From: Amanda Scholes on behalf of Planning.Responses
Sent: 07 February 2017 10:11
To: Planning Scanning
Subject: FW: P/76/16/PL WSCC Further correspondence (4th response)

Subject: Barfoots - accessibility contribution

**Figure 3:** Existing Car Parking Provision ([www.googlemaps.com](http://www.googlemaps.com))

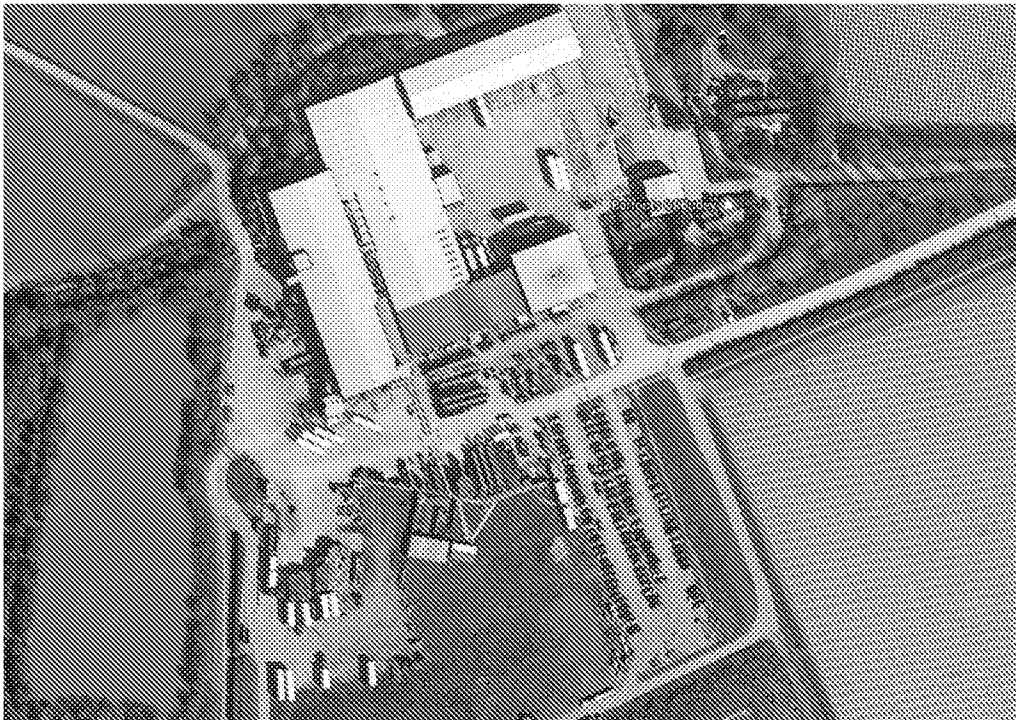
Finally parking, mini-buses and commercial bus service, etc. **Parking** – Happy to accept a parking plan (unmarked but with the capability to take 215 vehicles) would form part of any planning permission which can then be secured by planning condition. **Mini-bus** - The mini-bus route/s would remain to ensure that staff continue to be attracted to work at the Barfoots site. I shall simply refer to Barfoots using best endeavours to continue this within the Travel Plan as opposed to formally securing it conditionally or within a S106 Agreement (although any final Travel Plan would have to be secured using S106 or by planning condition). I ask though that you provide me with a brief written explanation as to how long the service has run and will continue to run, and why you run it. **Commercial bus service** - As you have committed to fund this for the six month period I would be minded to ensure this is secured within the aforementioned S106 Agreement. Similar to the mini-bus, it would be helpful to have sight of the patronage to date, please.
